Derby City Council Conservation officer comments:

I have the following heritage comments to make on the consultation document: -

Drawing Title  
FIGURE 2.6  
MARKEATON JUNCTION  
GENERAL ARRANGEMENT

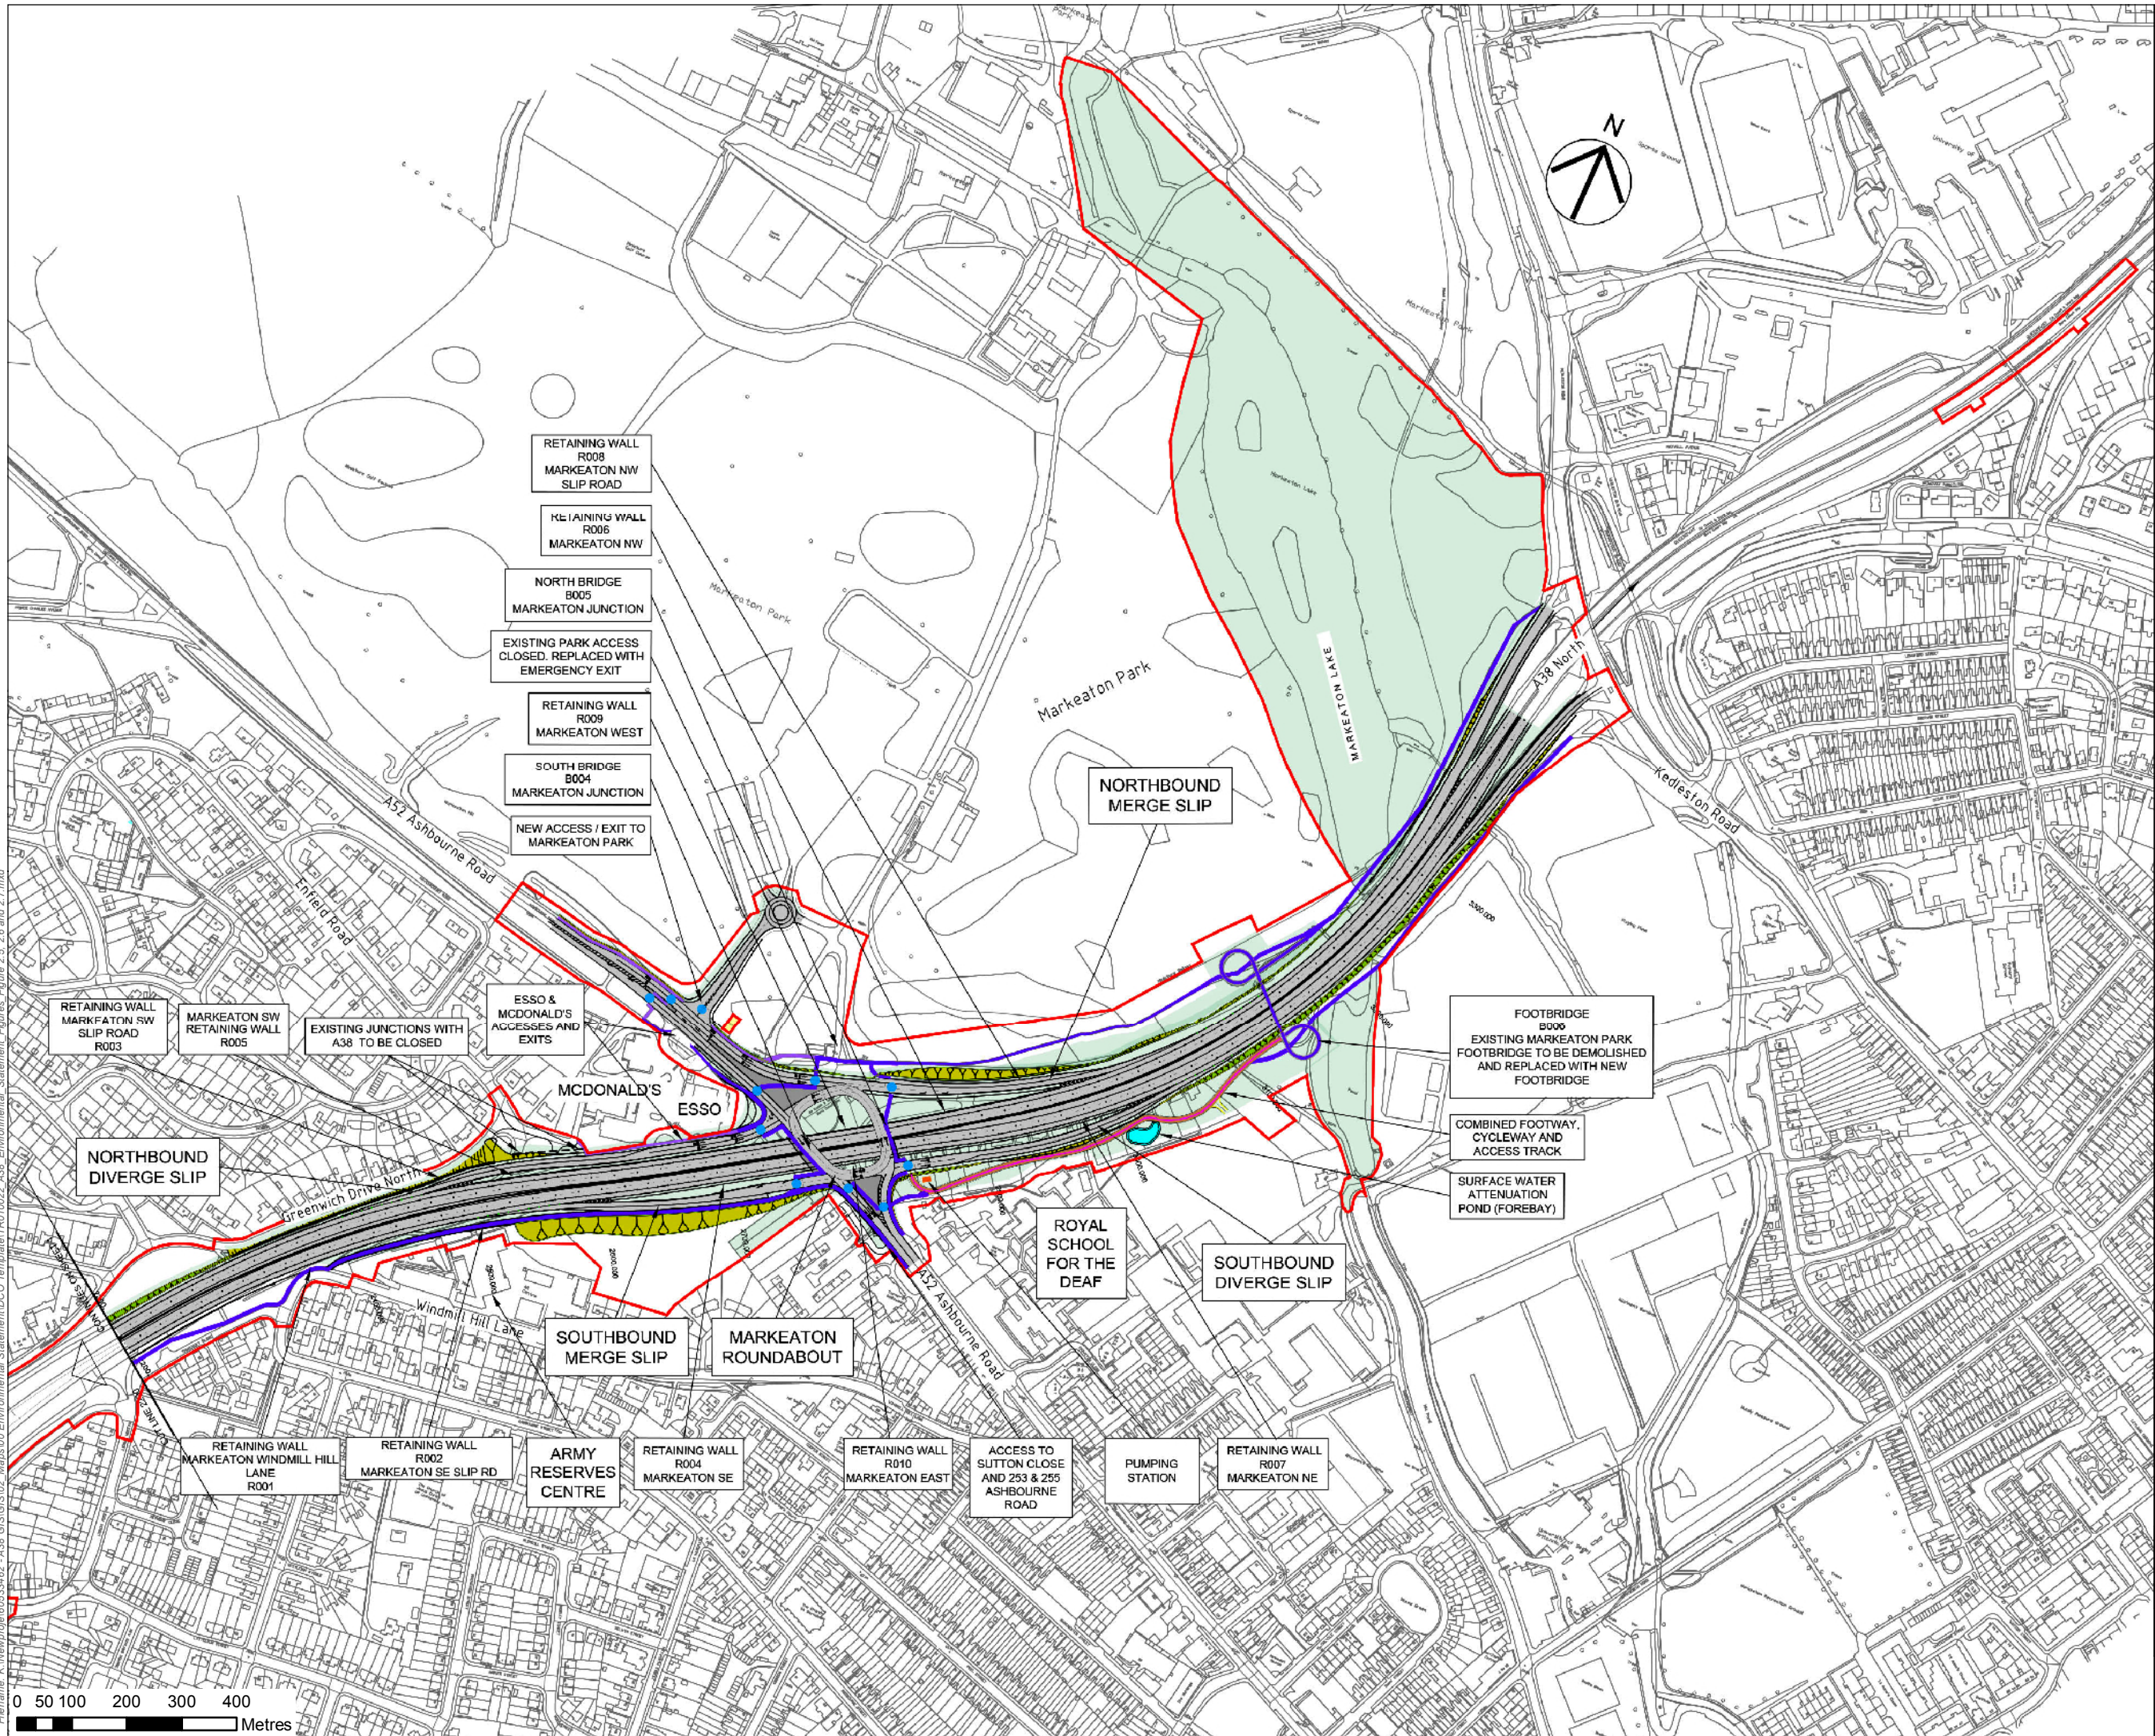
I note in the information they have referenced the comments we have made on the boundary stone walls, piers and gates at Markeaton Park but I cannot find any reference on whether these can be avoided in terms of impact or at least stone reused in the detailed design. I suggest retaining and reusing material in the detailed design will enable to retain some local distinctiveness in this area.

Markeaton Junction

- Markeaton Park is a heritage asset and the stone walls that enclose the park are an important part of the enclosure of the park. I suggest that as much of the wall is retained in the original location. If any walls are to be affected by this proposal I suggest that it is reused and the location where it is to be reused agreed.
- The Heritage Lottery gave a grant for the park including the relocation of the original park gates and railings to a low wall to adjacent to Ashbourne Road. I suggest these are kept in this location.
- I suggest part of the character of this part of the park is it's tree cover. I suggest that any loss of trees should result in appropriate tree planting in an agreed location.

Drawing Title  
FIGURE 2.7  
LITTLE EATON JUNCTION  
GENERAL ARRANGEMENT

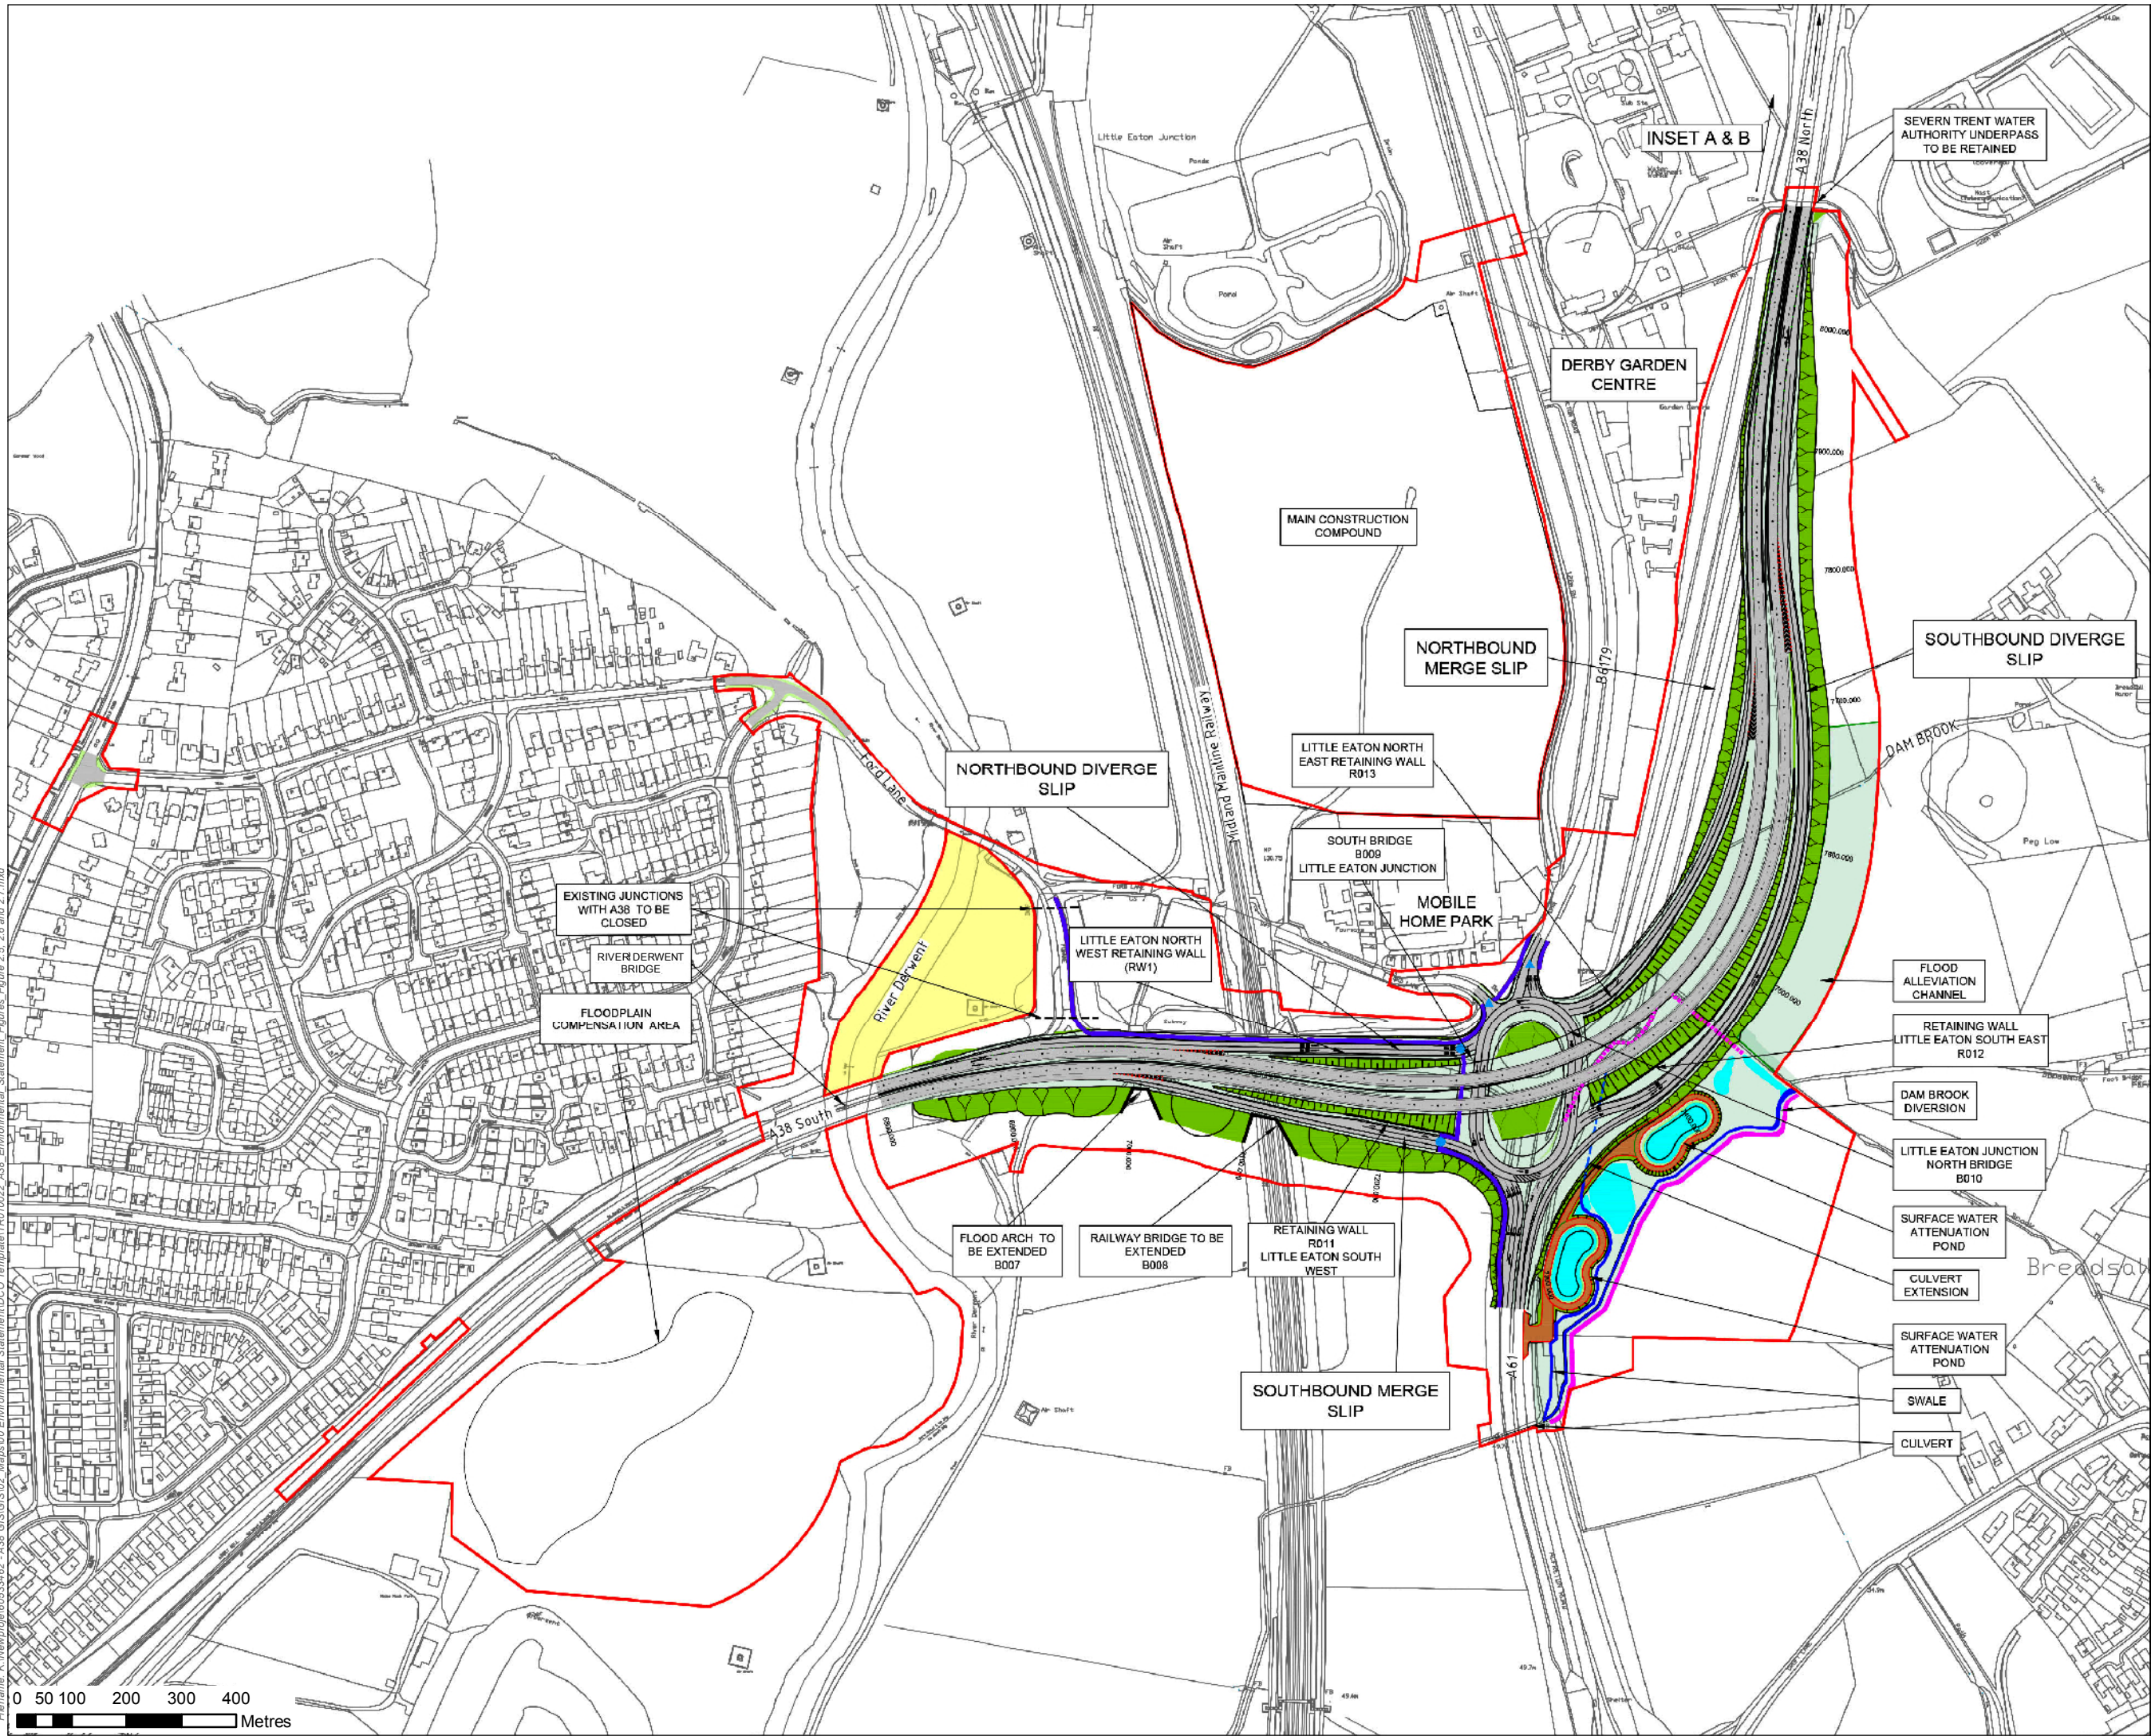
Little Eaton Junction

- **My main concern at this junction is the flood compensation storage area which is located within the Derwent Valley Mills World Heritage Site. This is near to an area (North Avenue Planning Public Enquiry) where there was a proposal for housing which was refused and dismissed at public enquiry. The character of this area, and it's rural nature, is very sensitive. The proposal would have a harmful impact on the OUV of the DVMWHS. I strongly suggest that other locations outside of the WHS and its buffer zone are looked at if this is needed.**
